WEST SUSSEX COUNTY COUNCIL CONSULTATION

TO:	Arun District Council FAO: Stuart Corbey
FROM:	WSCC - Highways Authority
DATE:	15 April 2019
LOCATION:	71 Hawthorn Road Bognor Regis PO21 2BS
SUBJECT:	BR/302/18/PL 1 x 2 bedroom flat and 2 x 1 bedroom flat to the east elevation. New plans elevations and floor plans.
DATE OF SITE VISIT:	
RECOMMENDATION:	More Information
S106 CONTRIBUTION TOTAL:	£ N/A

SITE PLAN (Proposed) @1:200

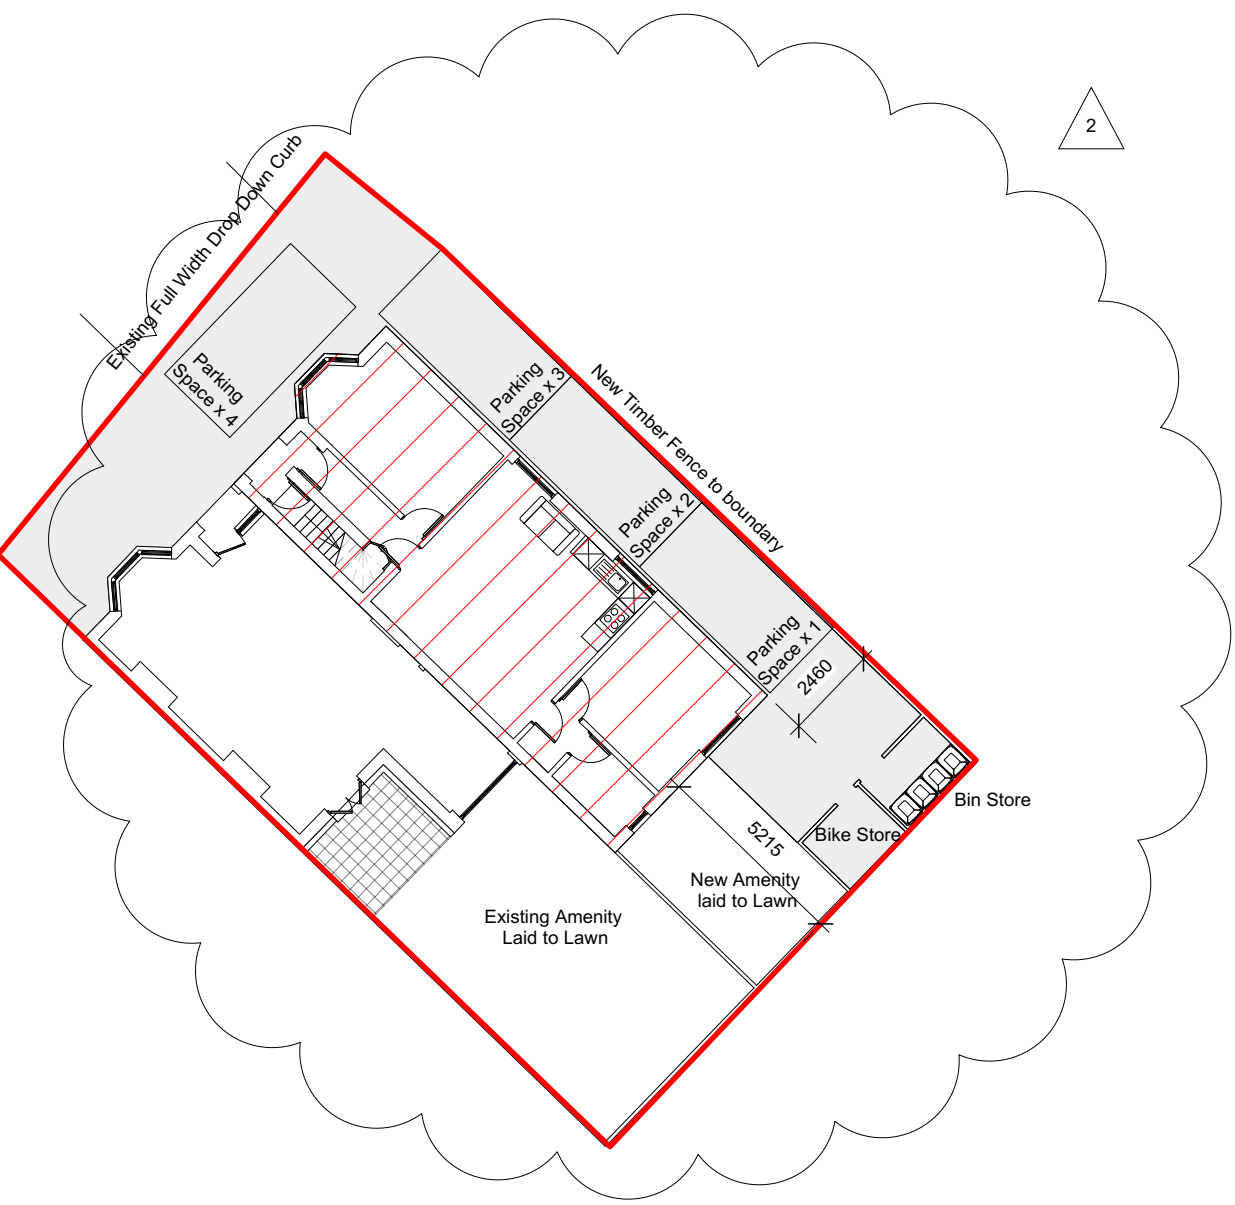
The parking layout shows a tandem arrangement, this parking arrangement works in practise for provisions serving a single dwelling where users have the ability to manage their parking arrangement between them, however it is not considered that this would be a workable solution for three independent flats.

The parking spaces also block the access to cycle parking and would seemingly prevent the ability to manoeuvre bins to the collection point on bin collection day, this matter would be an amenity consideration for the Local Planning Authority (LPA) to consider.

Parking space number 4 as a parallel parking space should measure 2m x 6m to accommodate for the additional manoeuvring room required.
It should be demonstrated where the parking will be for the host dwelling given that this proposal reduces the amount of space available within the site. I note that the dropped crossing only covers the centre of the site. It may be that this dropped crossing will require widening. I have consulted the area officer for Arun regarding this matter, additional comments will follow when his comments have been received.
